MAINE MEDICAL CENTER PROJECT ELEMENTS LOCATOR

Philip DiPierro - MMC Final C of O (13 Charles St)

RE: C. of O. for #22 Bramhall Street, Maine Medical Center Expansion
Project (Id#2004-0003) (CBL 053 G 001001)

Philip DiPierro - MMC - Emergency Department Site Plan

**C100**

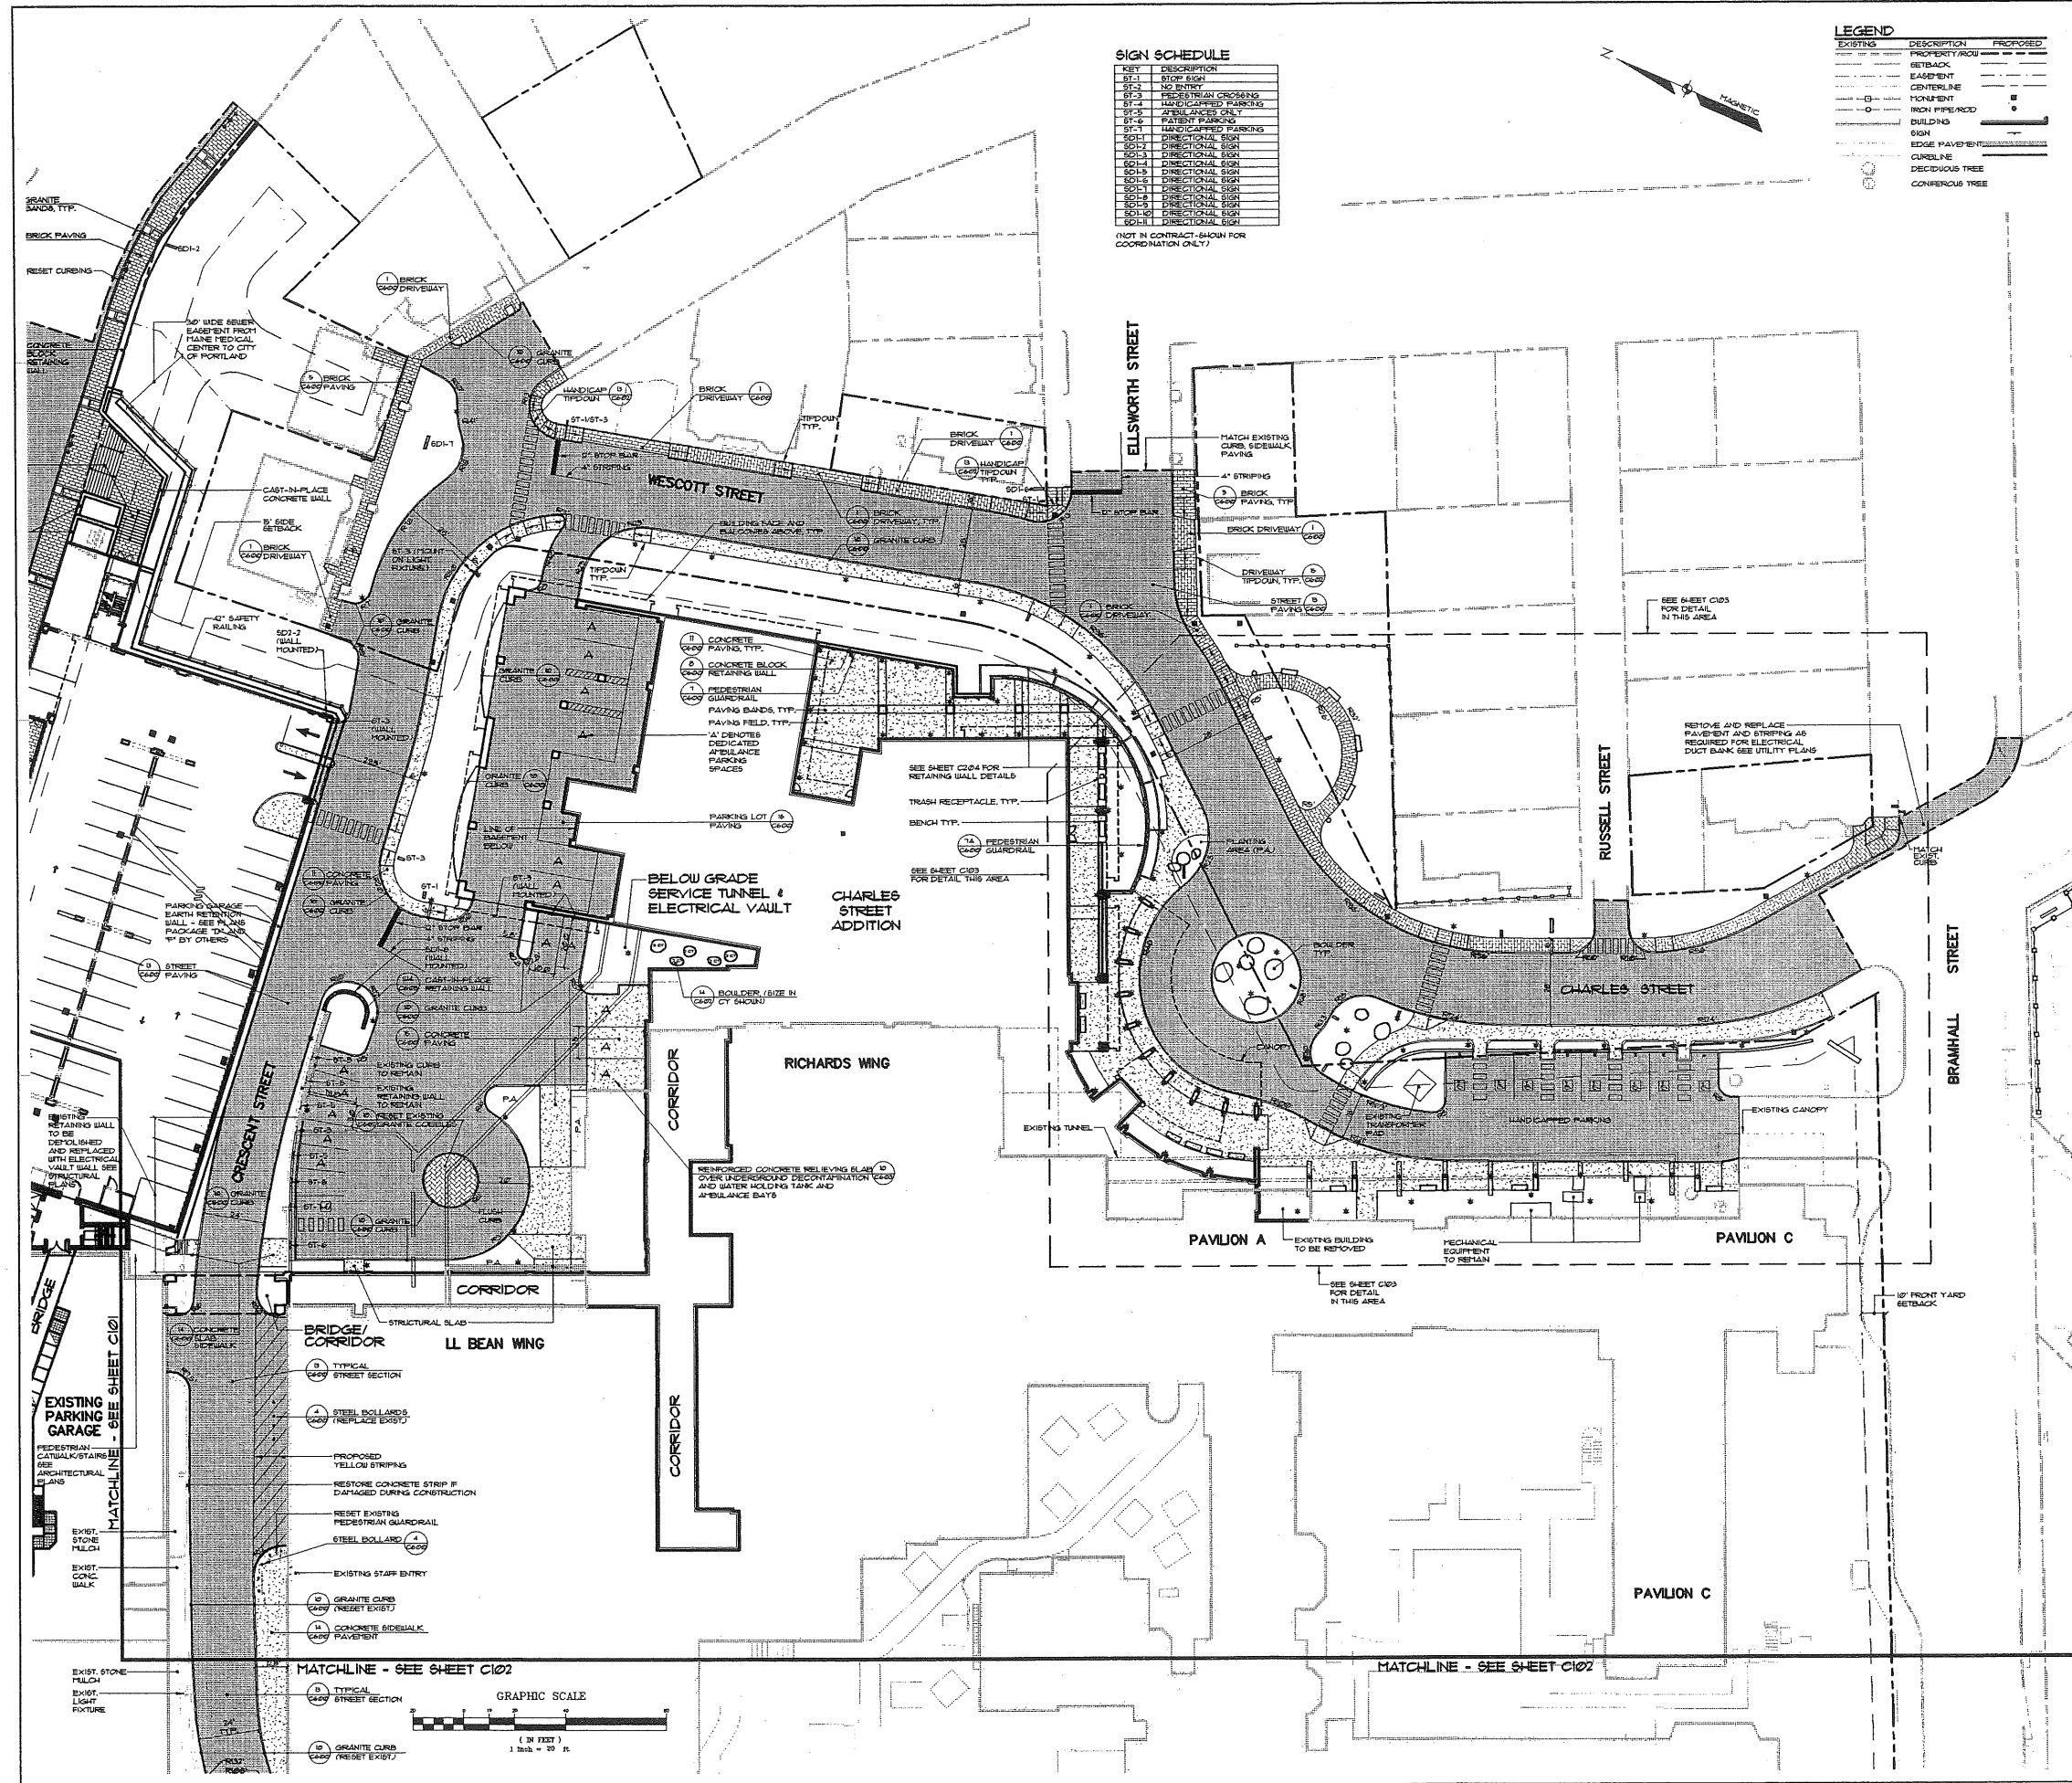
Phil -- I conducted a field review of the revised site plan (sheet C100) prepared by MMC dated October 27, 2009 and find conditions to be acceptable. During my field investigation I did identify two conditions that MMC should consider addressing. The first relates to limited sight distance (to the left) when exiting the Emergency Department parking lot. It may be beneficial to add some warning signs. The second is incorporating pavement markings and/or signage for the pedestrian crossing across on ambulance egress to the Emergency Department parking lot. Sight to and from pedestrians on the sidewalk are obstructed by structural columns.
